CITY OF ALBUQUERQUE

January 15, 2014

**Re: Family Dollar Store, 7700 Sage Rd. SW, Traffic Circulation Layout
Engineer's Stamp dated 12-10-13 (M10-D019A)**

FAMILY DOLLAR
F.F. =
5079.00

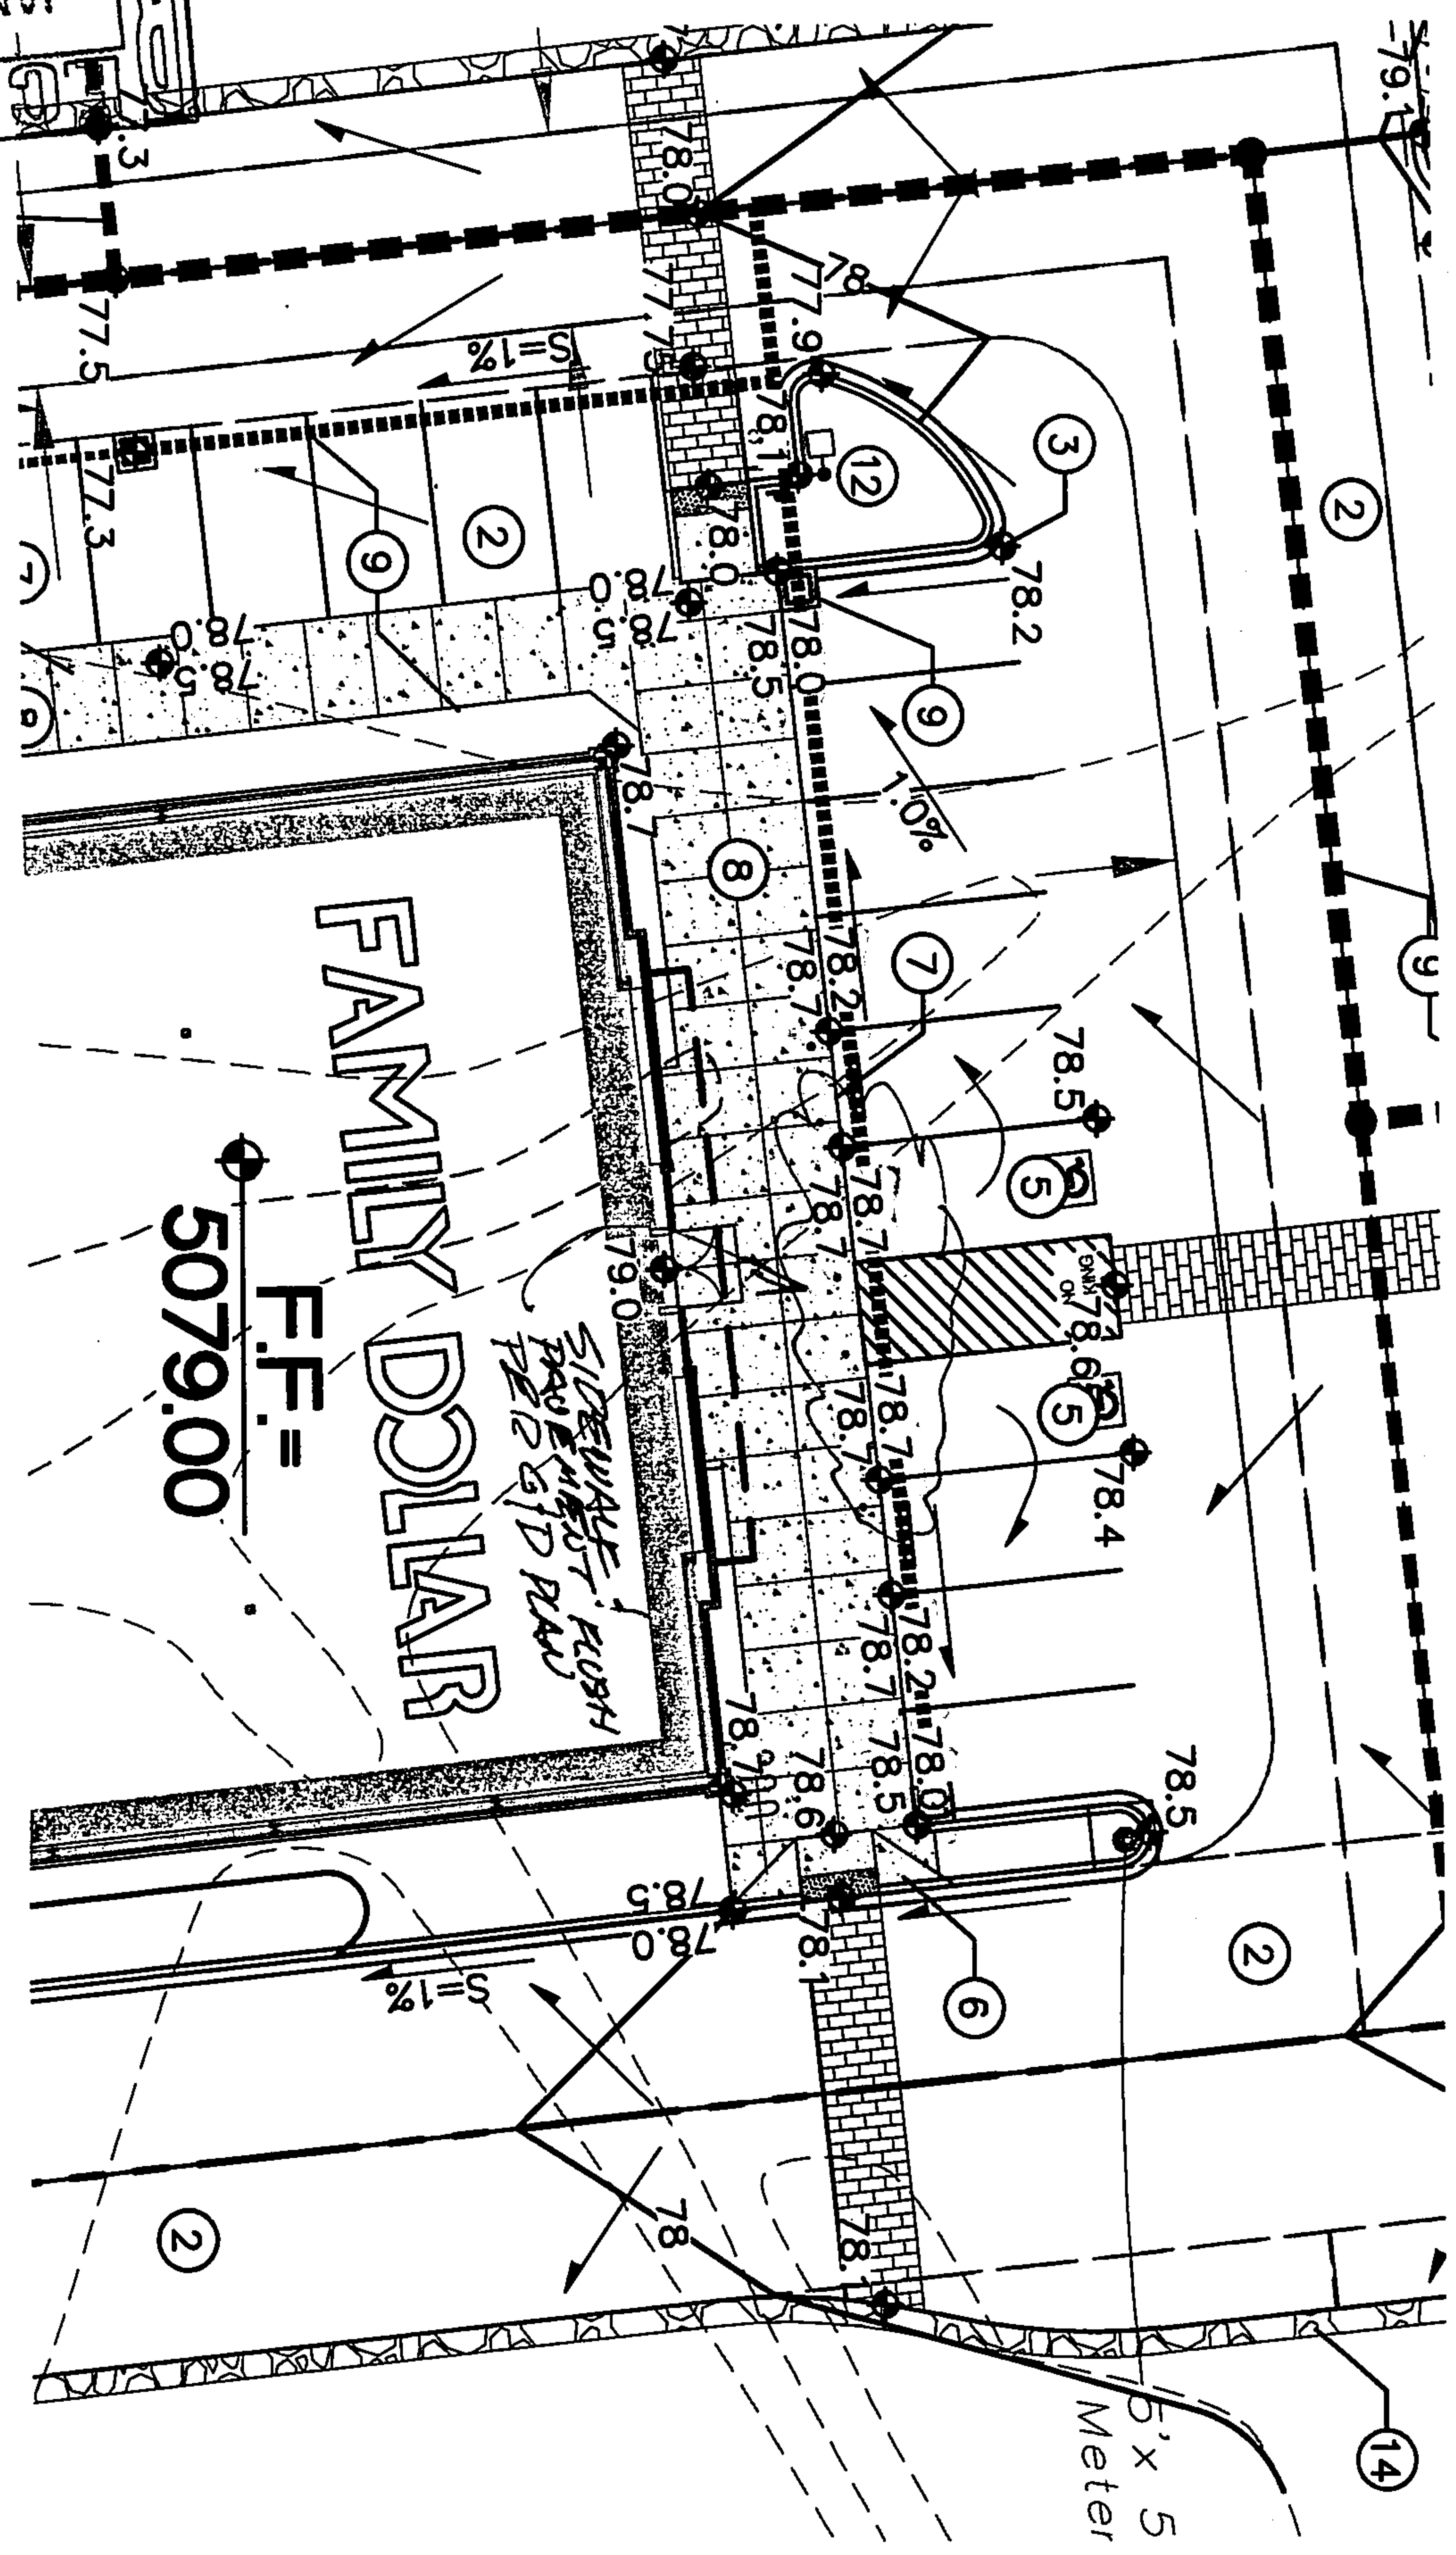
1. The minimum end island radius to accommodate cars is 15 feet. The proposed entry radius of 10' R is not in compliance with the *DPM Ch 23, Section 7, Part B.2 Treatment of Access Points*.

2. The entrance at Sage requires directional pavement signage; see *DPM Ch 23, Section 6, Part B.10 Striping and Signing*.
3. Regarding *12'X12' Sign Easement*: provide recorded easement information, provide proposed sign details, and provide a sight distance exhibit (see the *Development Process Manual, Chapter 23, Section 3, Part D.5 Intersection Sight Distance*) demonstrating proposed sign will not obstruct clear sight and stopping distance required.

4. Please label width of all proposed sidewalks. General Note 6 regarding all onsite sidewalks are 6' unless labeled conflicts with site plan & scaled dimensions. Please correct.

5. The labeled width for ADA Parking of 9' conflicts with General Note #3 of 11' and Detail A. Please align information.
6. The development of this site must be in compliance with current DPM and ADA standards and regulations. Please refer to attachment for revised ADA parking regulations addressing posted sign and pavement markings.

7. Please add the following note: "Landscaping and signing will not interfere with clear sight requirements. Therefore, signs, walls, trees, and shrubbery between 3 and 8 feet tall (as measured from the gutter pan) will not be acceptable in this area."

8. Please provide barricade plan for drive aisles that are not complete connections; see *DPM Ch 23, Section 5.M Barricades at Ends of Pavement*.
9. Please provide details of brick patterned line type (i.e. raised, colored, texture concrete).
10. Please clarify "bubbled" line type.
11. The parking provided is less than the required parking. Was a parking variance approved? Approved variance must be provided prior to approval of this proposed TCL.
12. Please include two copies of the traffic circulation layout at the next submittal.
